Date: 12-Jun-2025  
Our Ref: 2024/92949

**Application for Approval of Details Reserved by Condition  
Town and Country Planning Act 1990  
Planning (Listed Buildings and Conservation Areas) Act 1990**

**Discharge of conditions 9 (retaining walls), 17 (Phase II Report), 18 (remediation), 21 (coal mining), 23 (charging facilities), 24 (facing materials) and 27 (construction management plan) of previous permission 2021/92528 for erection of retail development, associated parking, servicing areas and landscaping  
Land off Bankwood Way, Birstall Retail Park, Birstall, Batley, WF17 9DT  
Application Number: 2024/92949**

Drawing Title: **HOME BARGAINS SITE PROPOSED PLAN & SITE SECTIONS**

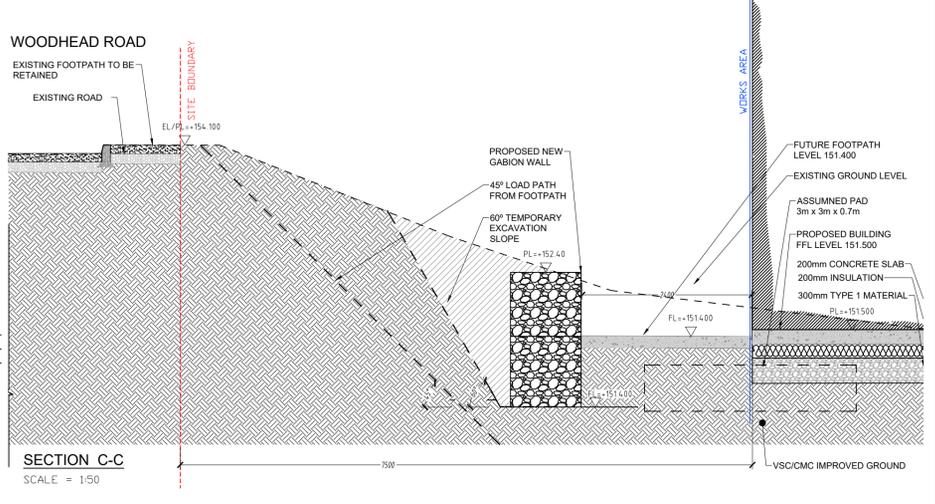
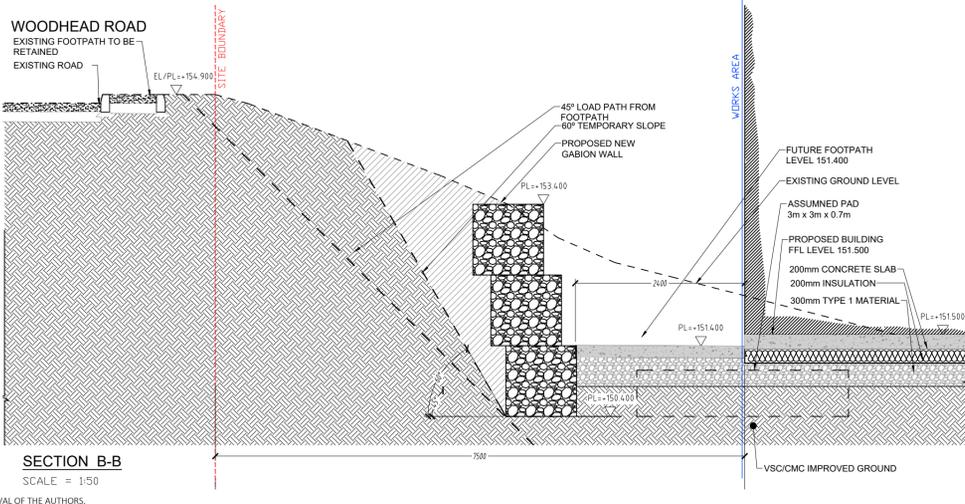
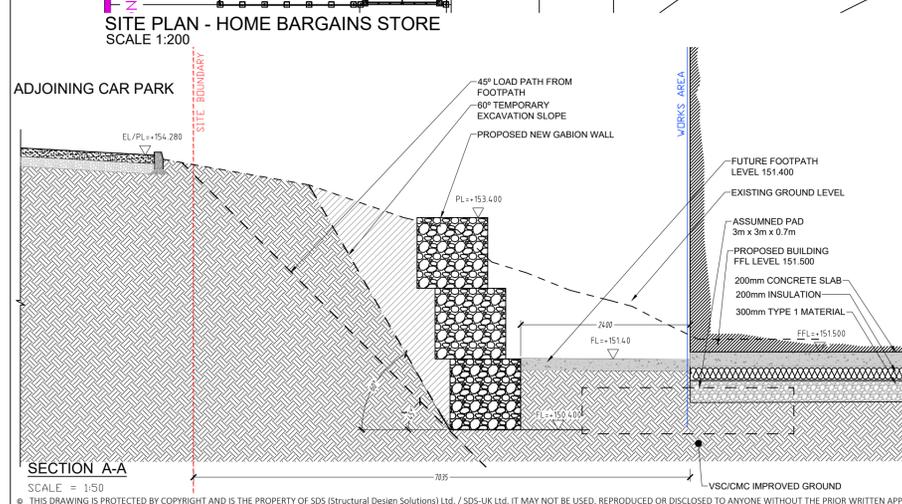
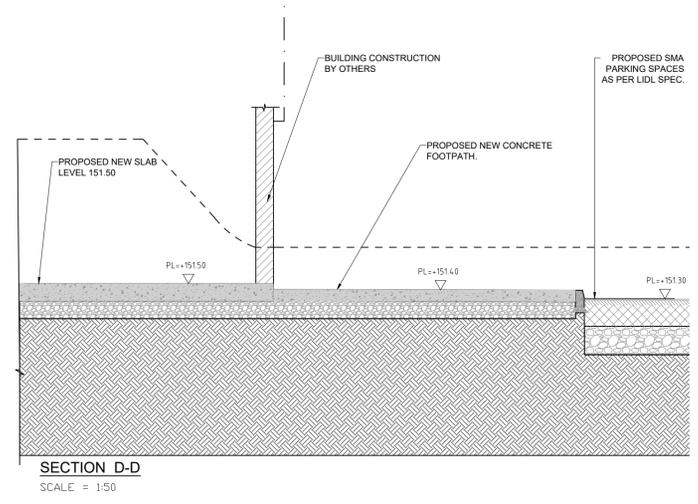
The following documents were, however, submitted to the Local Planning Authority on 30/05/2025 and it is understood that a new application has been made for AIP, based on the following new plans:

- Proposed gabion wall sections, 24062-SDS-00-XX-DR-C-3050 T3
- Proposed gabion wall elevations, 24062-SDS-00-XX-DR-C-3051 T3

The plans already submitted and approved for AIP purposes must therefore be treated as superseded. The more recent plans are at an early stage in the process of assessment for AIP and cannot be approved for planning purposes until a new AIP has been granted. This condition therefore cannot be discharged at this stage.

Drawing Title:  
**HOME BARGAINS SITE  
PROPOSED RC WALLS SHEET 3 OF 5**

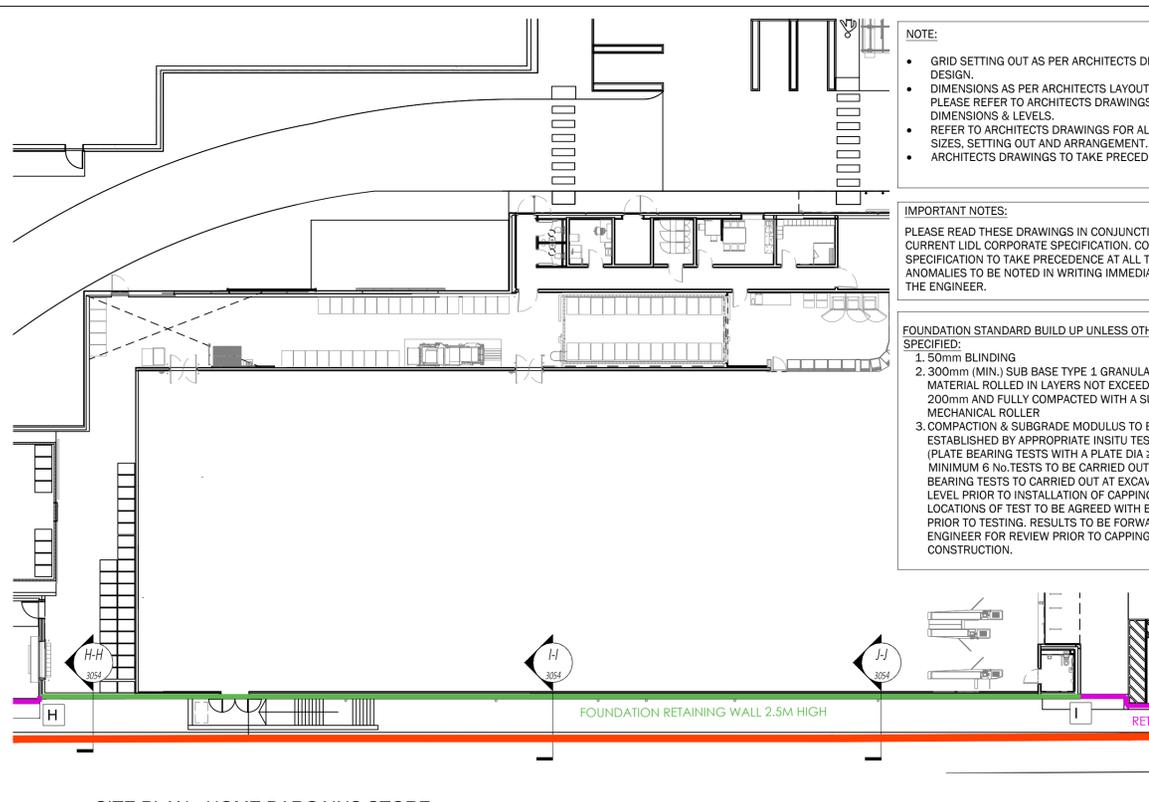
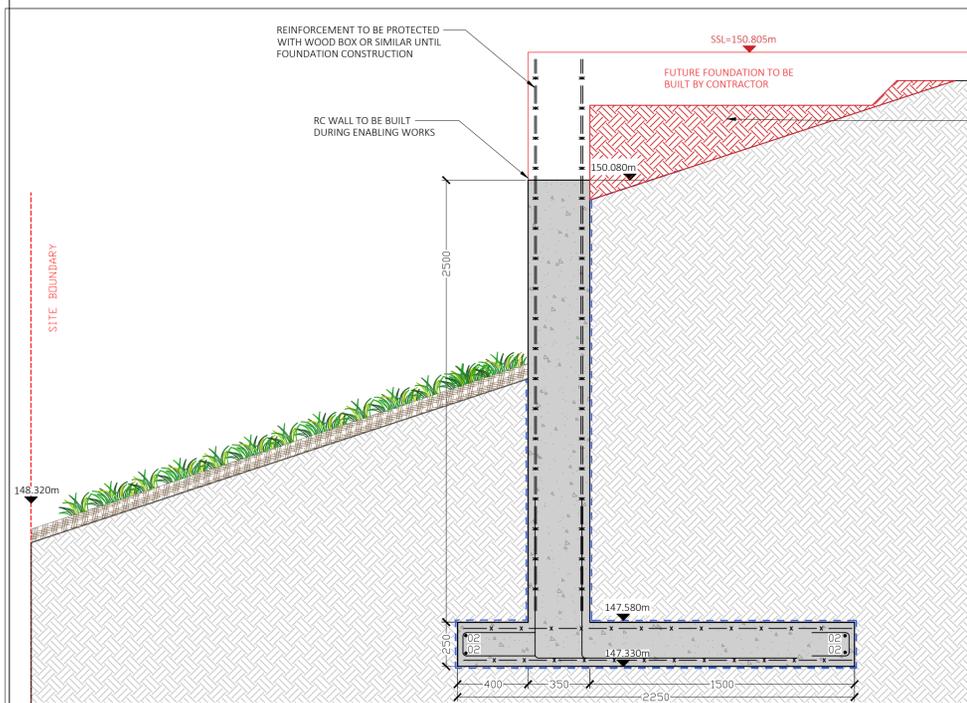
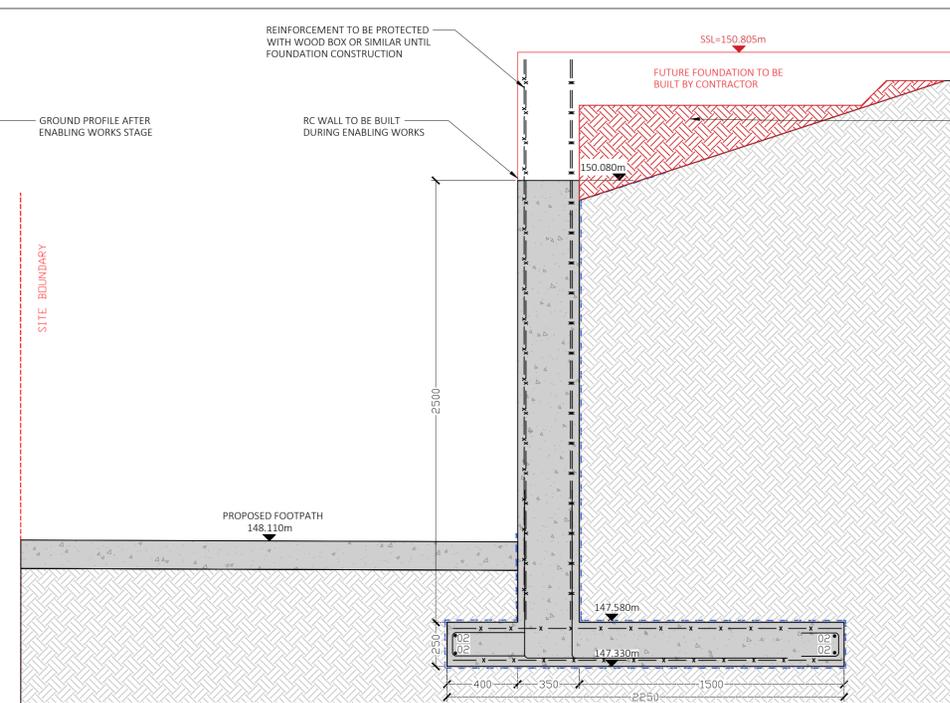
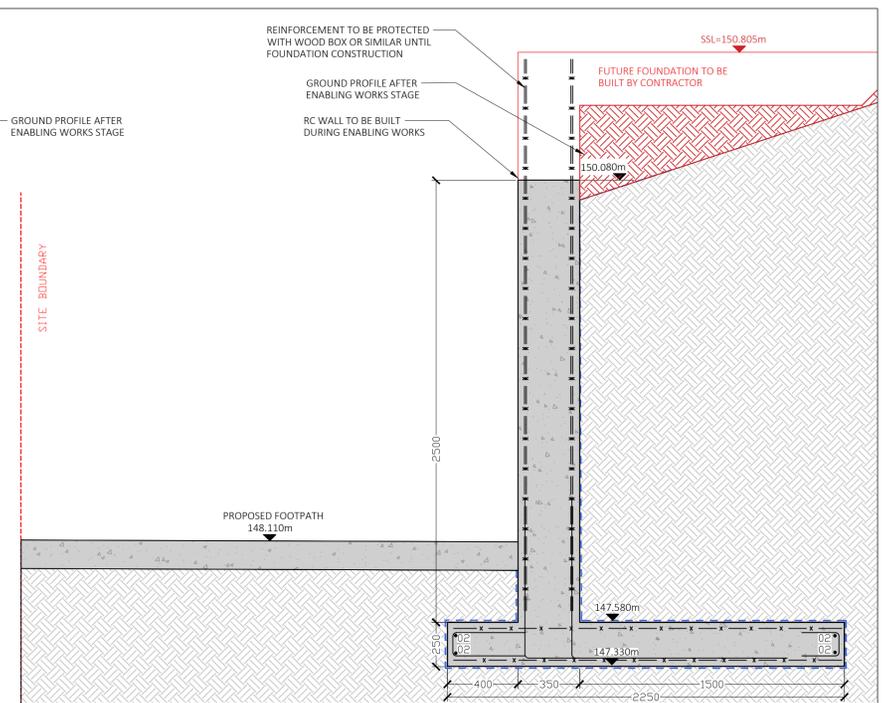
- Sections through proposed RC (reinforced concrete) walls, 24062-SDS-00-XX-DR-C-3052 T3, 3053 T3, 3054 T2, 3055 T3
